Our reference: ECM: 9970691  
Contact: Kathryn Saunders  
Telephone: (02) 4732 8567

13 April 2022

**Modification Application for Oakdale West Estate Precinct - Mod 10 (SSD-7348-Mod-10)**

Revised Precinct 5 layout

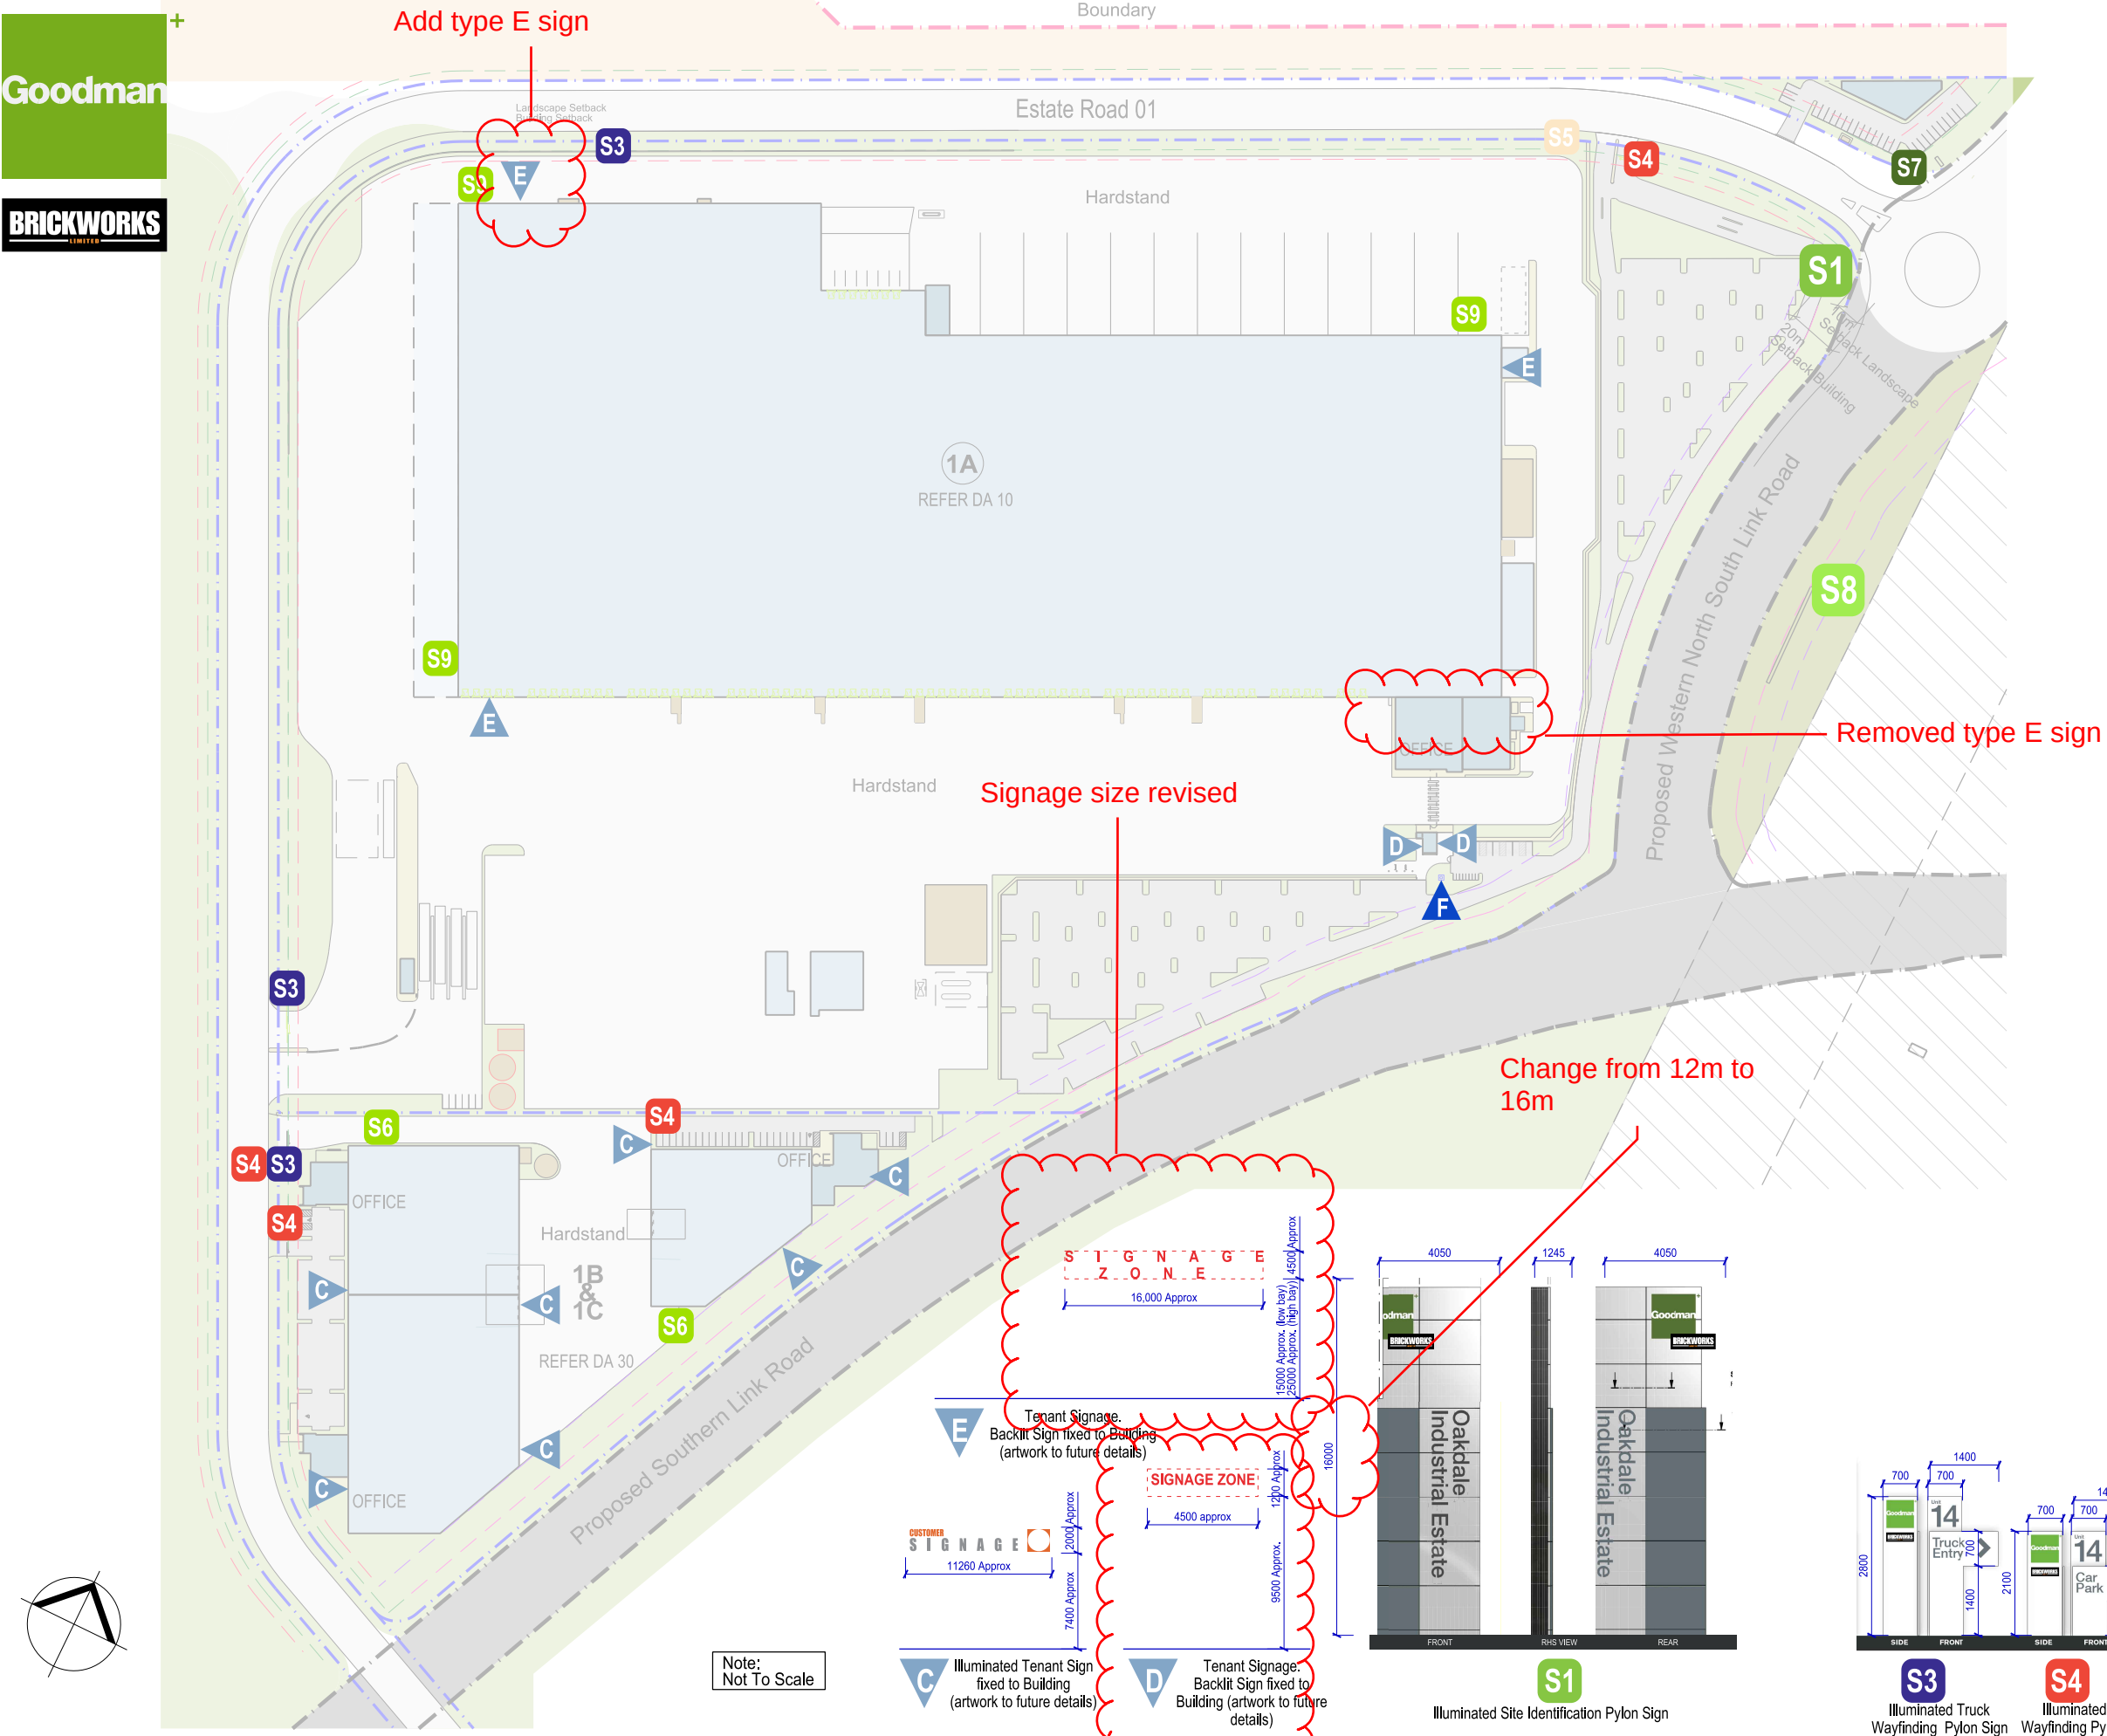
Council objects to the site layout proposed for Warehouses 5A and 5B.

Council strongly recommends that the Department request that the site layout be amended to provide safe and separated access from the staff and visitor parking to each office and warehouse. Future development applications for warehousing in this arrangement will not be supported by Council.

Staff and visitors must not be required to cross heavy vehicle driveways and manoeuvring areas. Secondary measures such as line-marking and boom gates should not be considered. Secondary measures are subject to user error and Council cannot manage compliance with consent conditions surrounding use and management of such systems.

The access driveways and crossovers within the cul-de-sac of Tundra Close are not perpendicular to the roadway (see access for warehouse 5A2) which should not be supported.

Due to the number of access points provided to each building from Tundra Close, competing, and unsupportable heavy and light vehicle manoeuvres will likely occur. Staff and visitor parking access is to be separated and located furthest from the heavy vehicle access/egress points.

Tundra Close could be extended toward east to provide sufficient and safe separated heavy vehicle access.

Strong consideration shall be given to requiring shared truck entry and exit point for the two warehouses. Warehouse 5A1 could also be rotated 90 degrees clockwise to separate access.

Warehouse 5A2 is not provided with separated entry and exit points for heavy vehicles. It has not been made clear from plans provided, that a conflict will not arise when entering and exiting heavy vehicles meet on this same driveway. Separate entry and access points for heavy vehicles are to be provided for 5A2.

The current arrangement of entry and exit points in the cul-de-sac and location and design of truck manoeuvring/driveways and staff parking and access points should not be supported and must be re-designed.

Further to the above, the design and layout of the warehouse on Lot 5A appears to facilitate more than one operator.

Should this warehouse be split into two and operated by separate tenants, the rear (northern) portion of the warehouse will need to be provided with staff and visitor parking which does not require pedestrians to traverse areas of hardstand which are utilised by heavy vehicles and which does not require excessively long paths of travel.

The layout would need to be amended to provide separated heavy vehicle, and staff and visitor access points.

- (g) The proposed modification seeks a total of five (5) driveways accessing the site from the cul-de-sac. Heavy vehicle movements will conflict with staff and visitor car parking movements within the cul-de-sac, which is not supported.
- (h) Safety concerns are raised for the location of the staff car park for Warehouse 5A1 as pedestrians will be required to cross the heavy vehicle driveway to access the building which is not supported.

The previously approved Masterplan for Precinct 5 had separated the heavy vehicle areas from the staff car parking areas. The use of a boom gate and traffic signal system is not supported.

The application shall be supported by turning paths for the largest vehicle expected to access the site in accordance with AS 2890 clearly demonstrating satisfactory vehicle manoeuvring on-site and forward entry

and exit to and from the public road. Turn paths for all driveway access points from the cul-de-sac of Road 8 are also to be provided.

1 ELEVATION NORTH - WAREHOUSE 5A 1 : 500

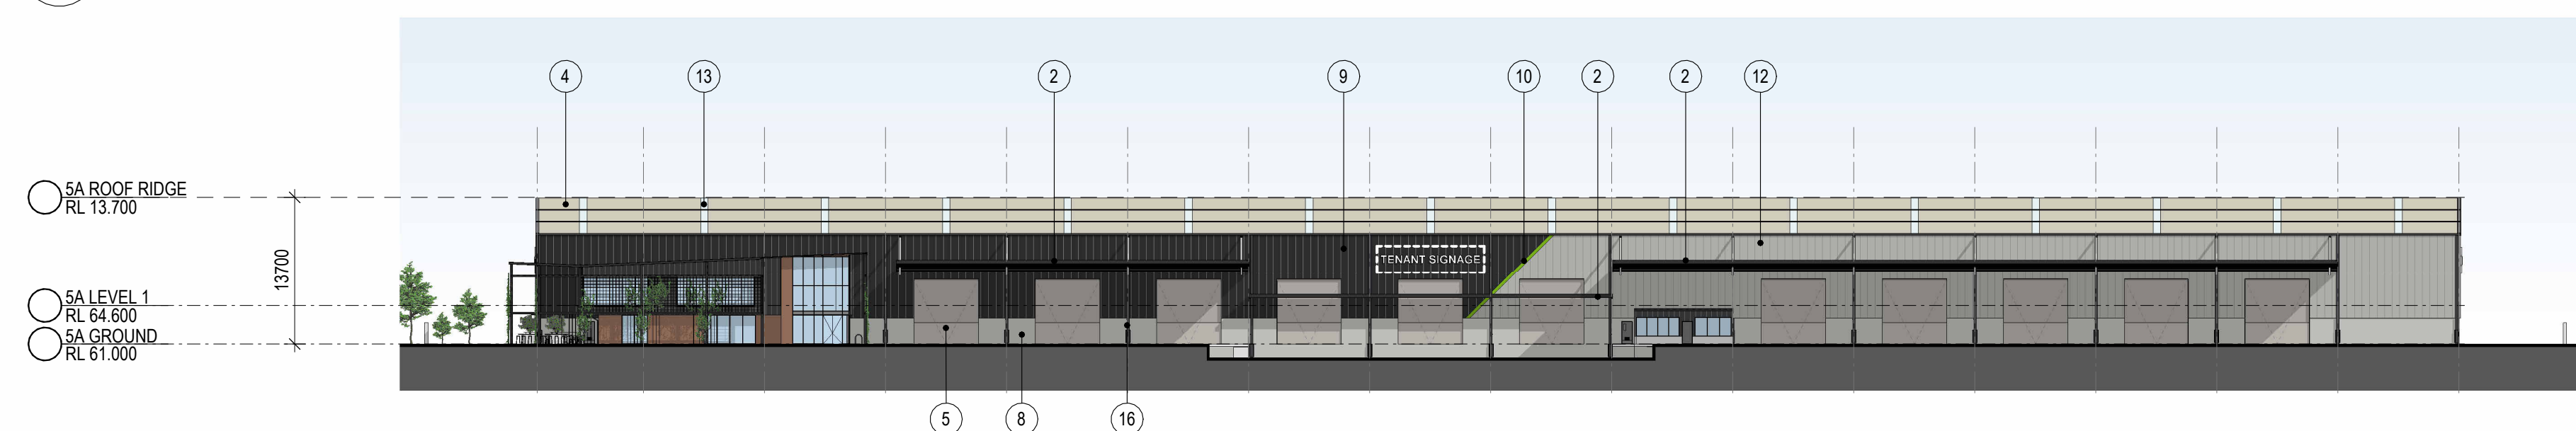
Warehouse buildings including gatehouse structures are to be provided with easily accessible and convenient amenities and staff areas. It is noted that the second gatehouse and dock office (north elevation of Warehouse 5A) is relatively isolated from the office amenities and that any additional warehouse amenities are not indicated.
